### FINDINGS OF FACT Walker Short Plat (SP-06-41)

### RE: Walker Short Plat (SP-06-41)

The Kittitas County Community Development Services Department has determined that the Walker Short Plat is a complete application and hereby grants **conditional** preliminary approval subject to the following conditions:

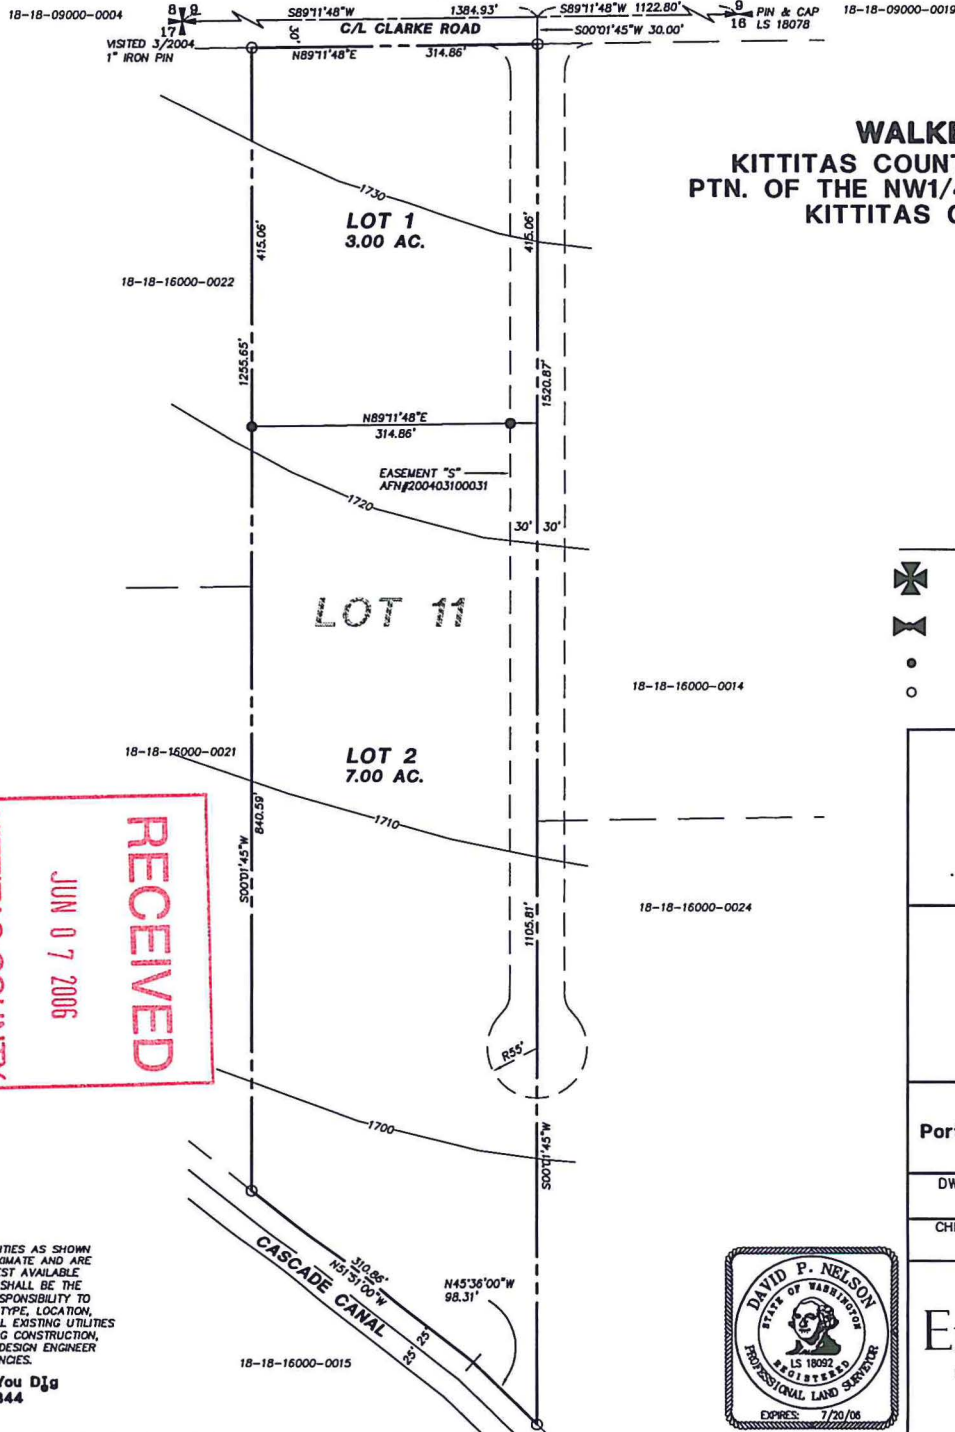
1. Both sheets shall reflect the short plat number SP-06-41.
2. Pursuant to Kittitas County Code 17.74.060A, a Plat Note regarding the Right To Farm Ordinance is required. The note shall read as follows: "The subject property is within or near land used for agriculture on which a variety of commercial activities may occur that are not compatible with residential development for periods of varying duration. (RCW 36.70A.060(1)) Commercial natural resource activities performed in accordance with county, state and federal laws are not subject to legal action as public nuisances." (RCW 7.48.305).

1. Access for Lots 1 and 2: Access for Lots 1 and 2 shall be via the 60' access Easement "S" as shown on the face of the preliminary plat. Access shall meet or exceed all applicable current Kittitas County Road Standards.
2. Private Road Improvements: Access shall be constructed as a Low-Density Private Road. (See current Kittitas County Road Standards)
  - a. Access easements shall be improved to a minimum of 60' as shown on the face of the plat. The roadway width shall be 20', with 1' shoulders = 22' total width.
  - b. All easements shall provide for AASHTO radius at the intersection with a County Road.
  - c. Minimum centerline radius shall be 60'.
  - d. Surface requirement is 6" for gravel surface.
  - e. Maximum Grade is 8% for flat, or 12% rolling or mountainous.
  - f. Stopping Site Distance, reference AASHTO.
  - g. Entering Site Distance, reference AASHTO.
